**Building Permit Request for 183 Ribbon Oak Court, Sanford, North Carolina 27332**

Revisions to Deck Addition Plans

Revised Plan

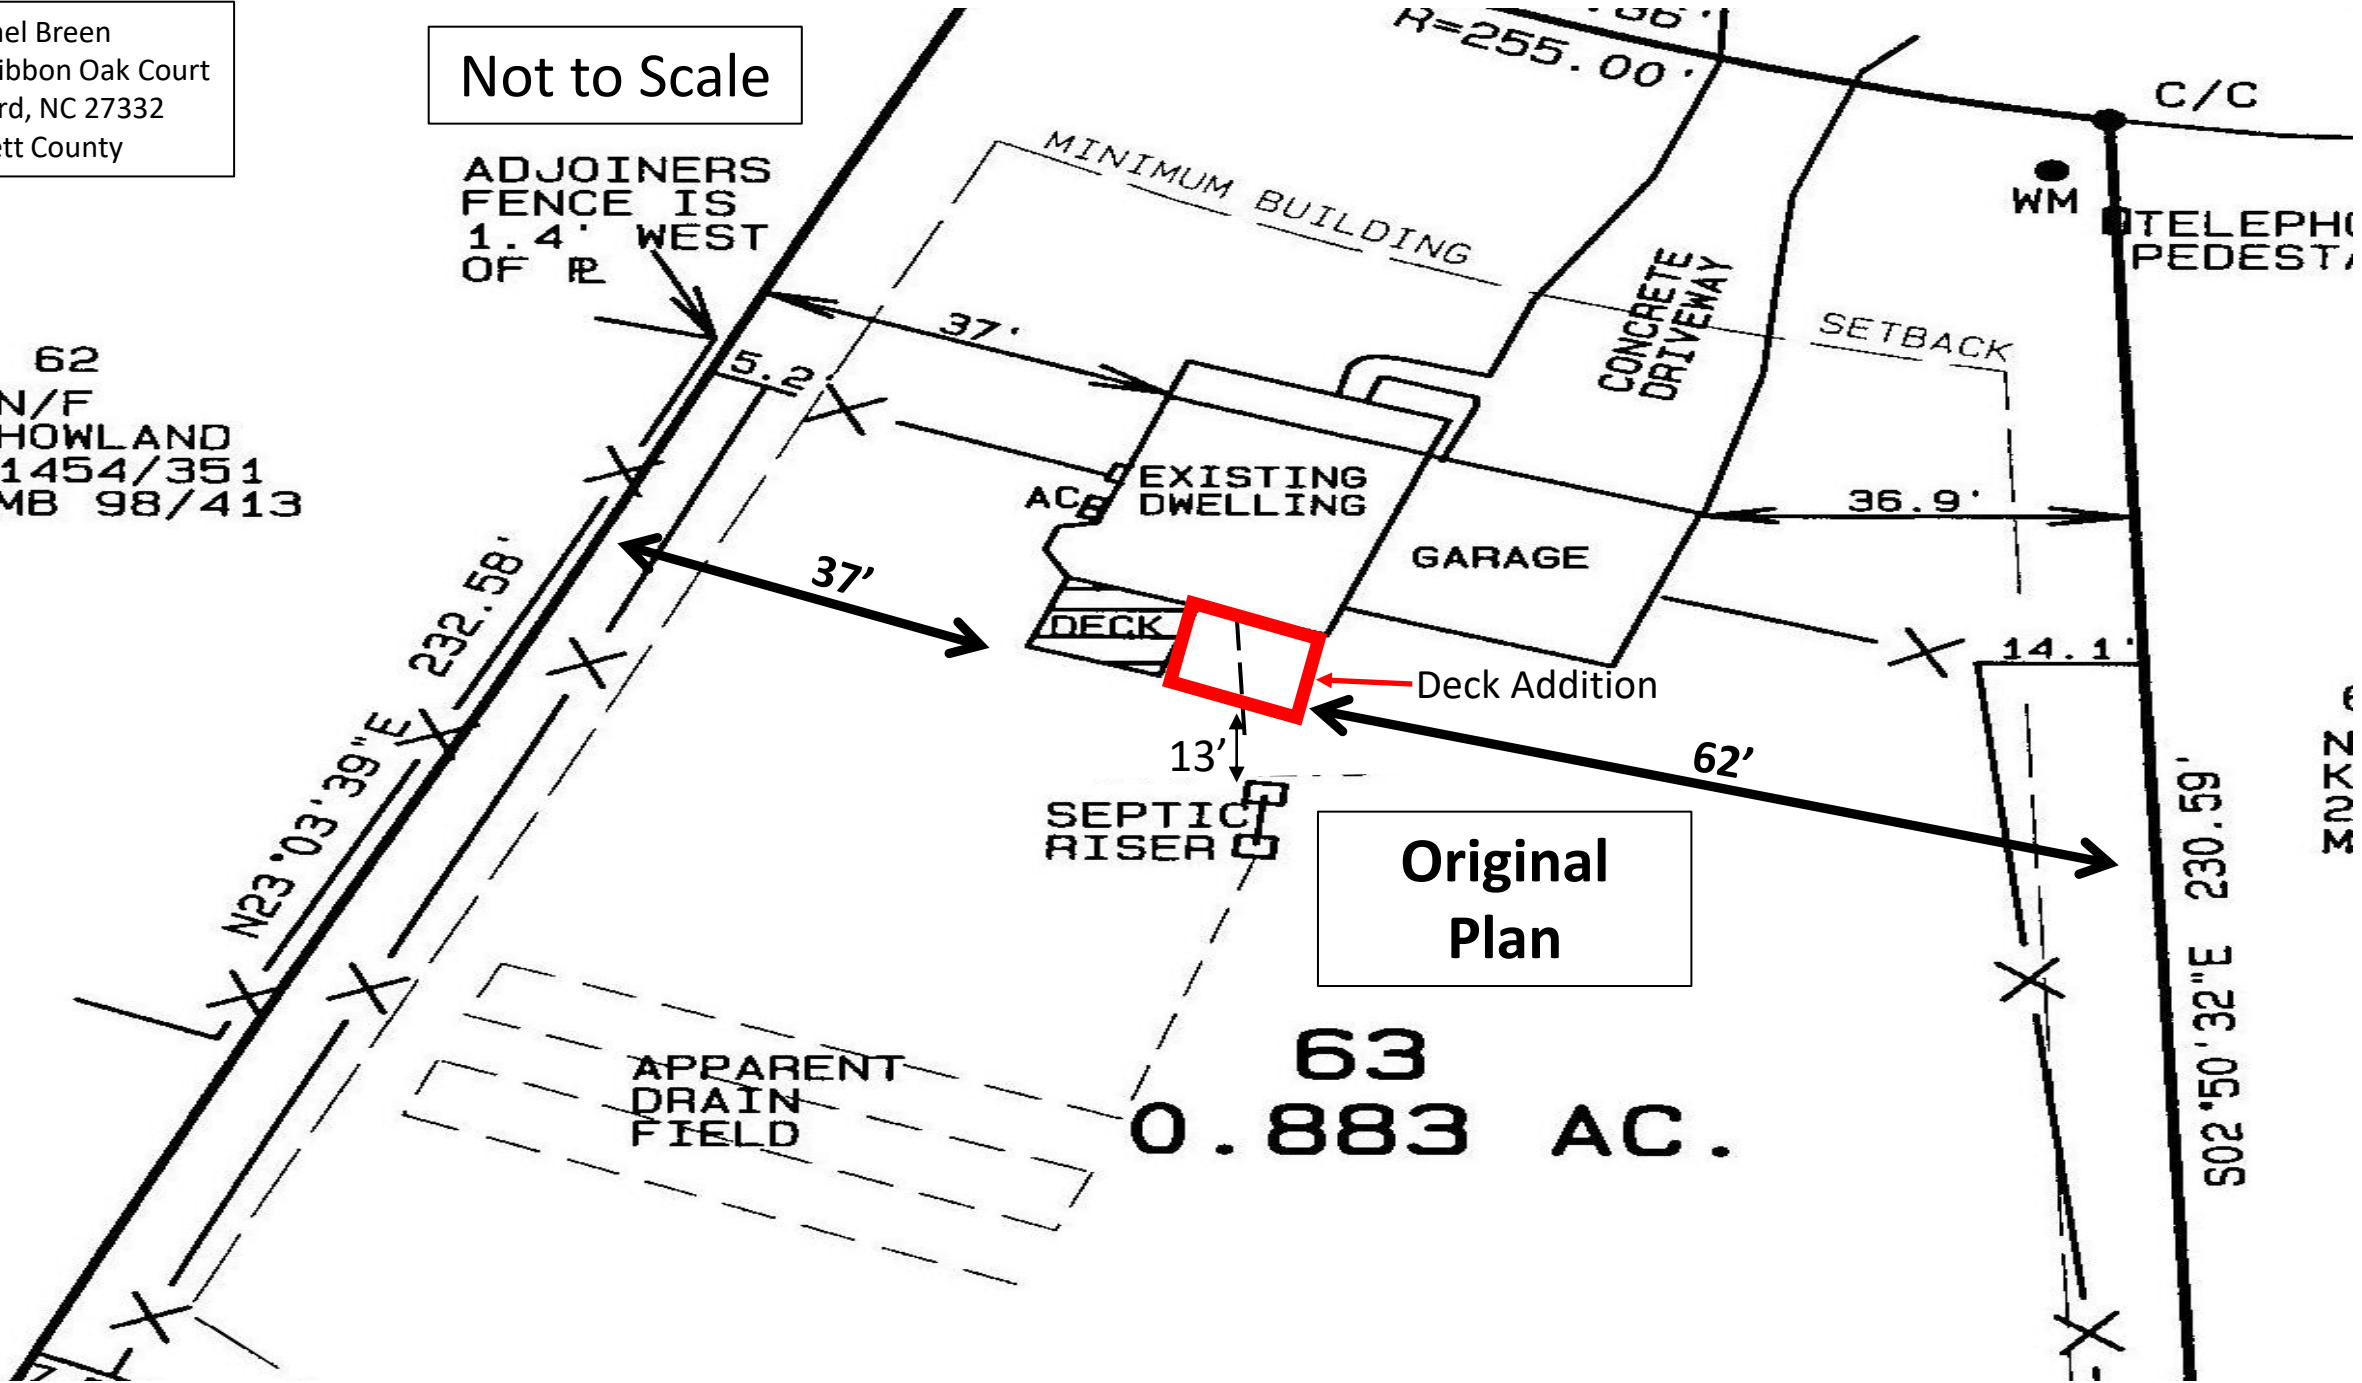
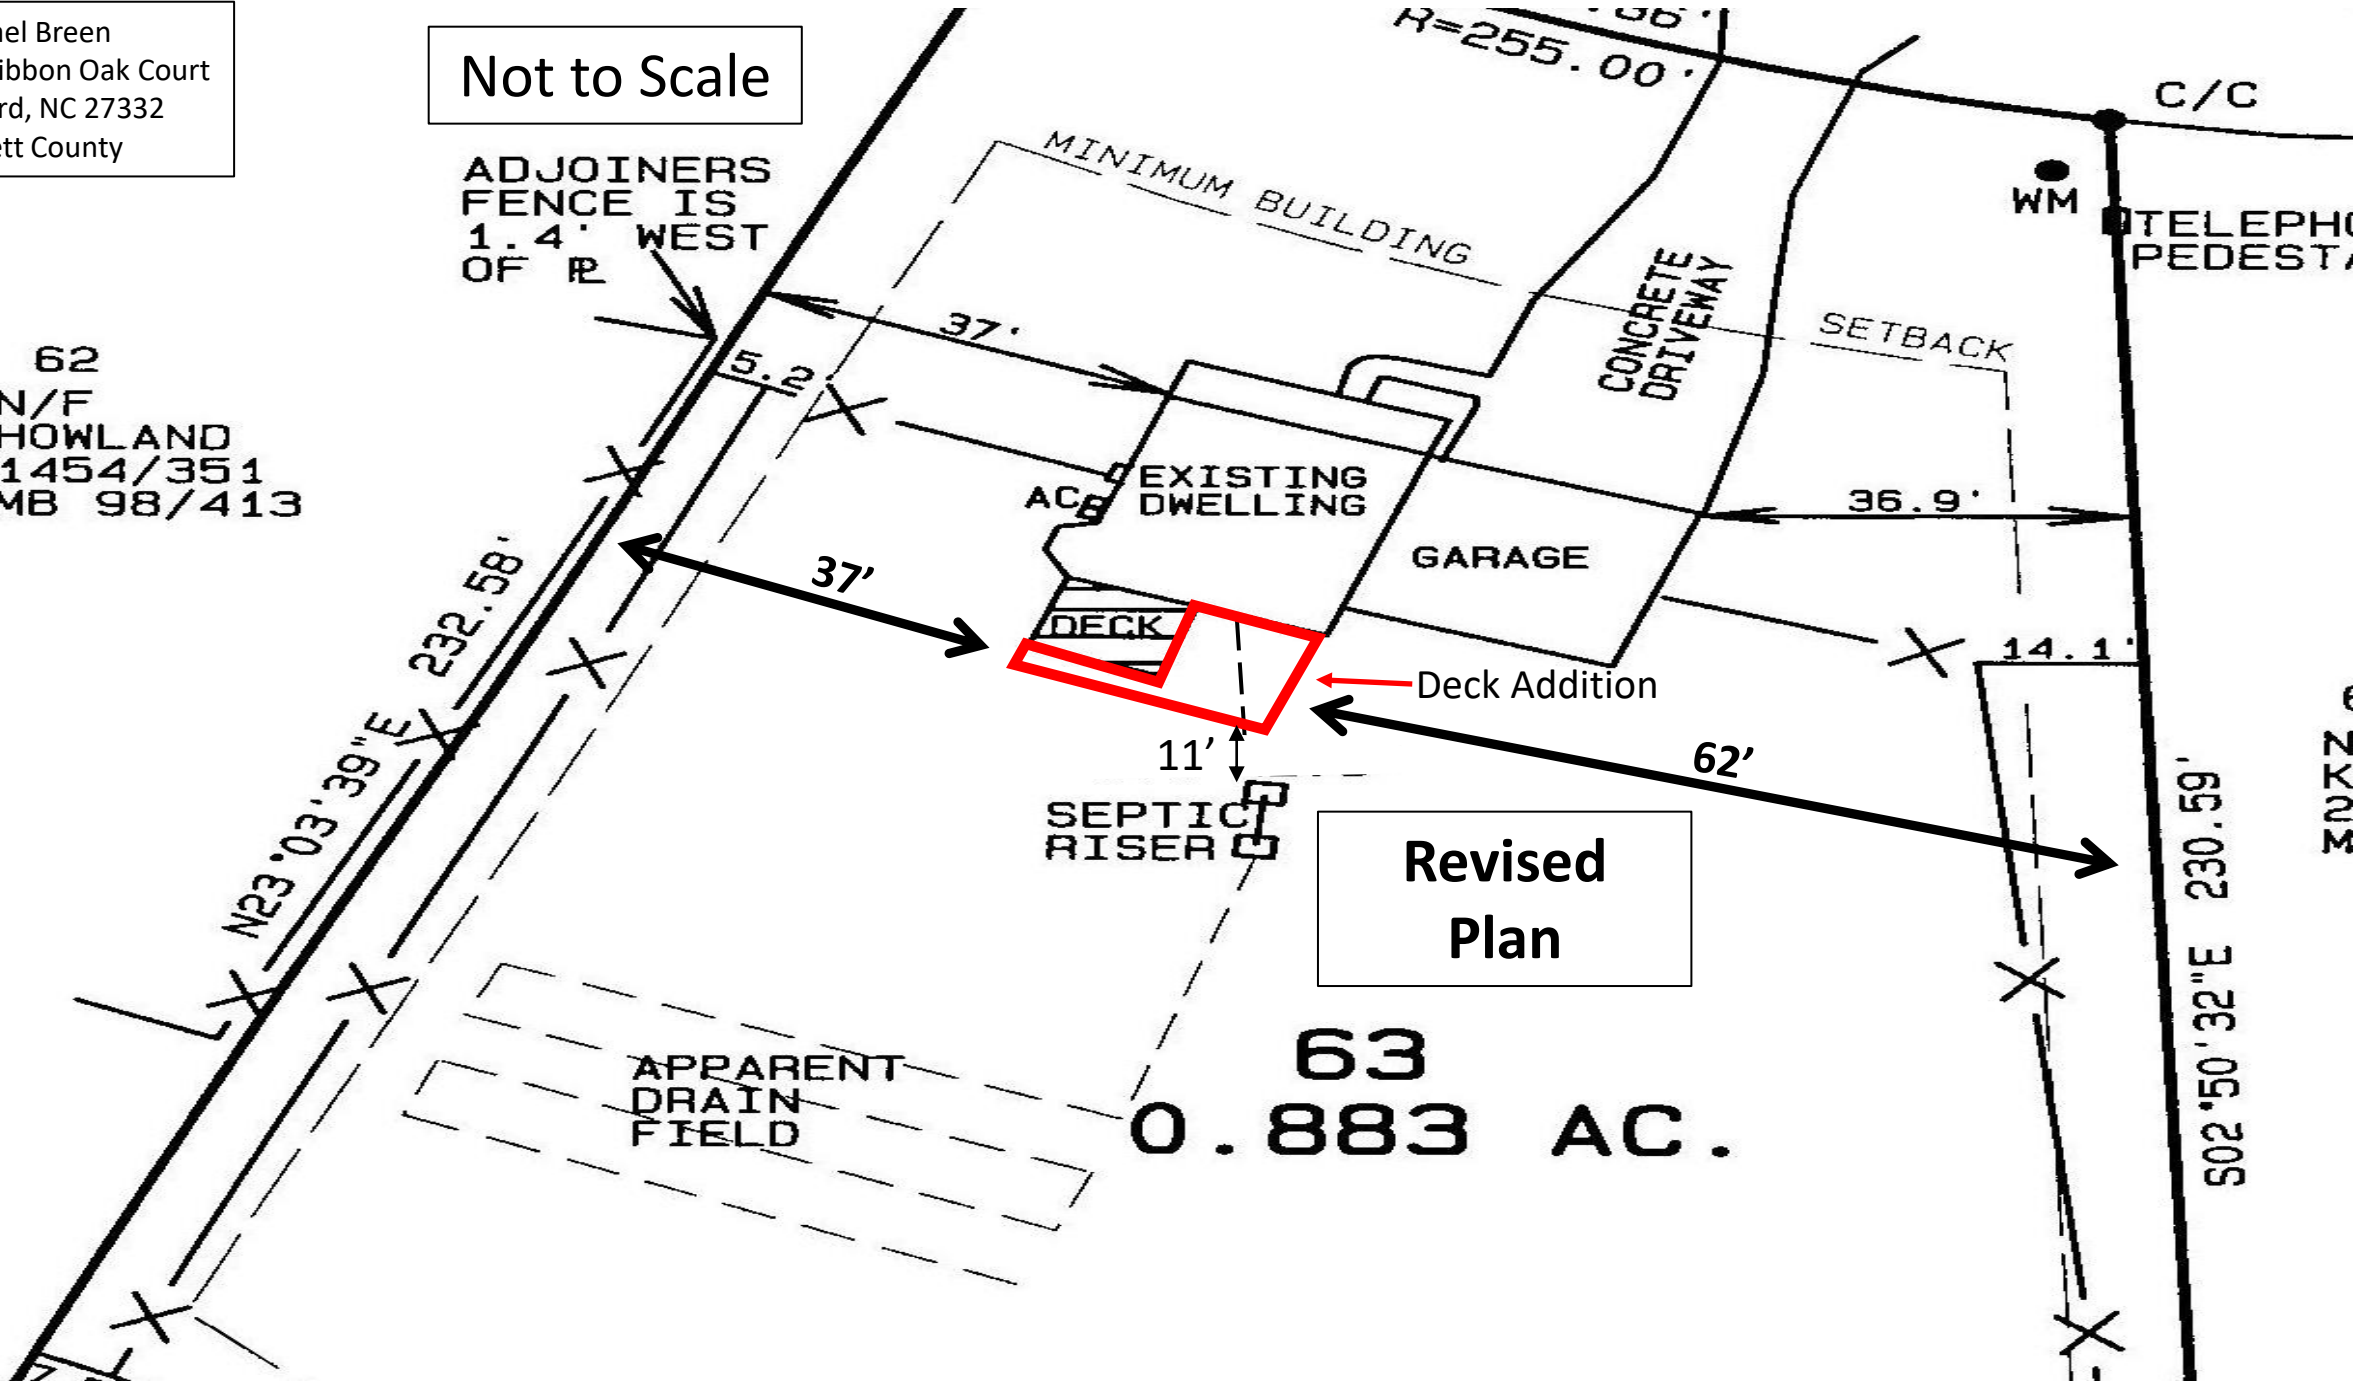
Amendment to Add to Overall Finished Dimension: 2x24' (48 sq/ft).

Planned Overall Finished Dimension: 12x24' (288 sq/ft).
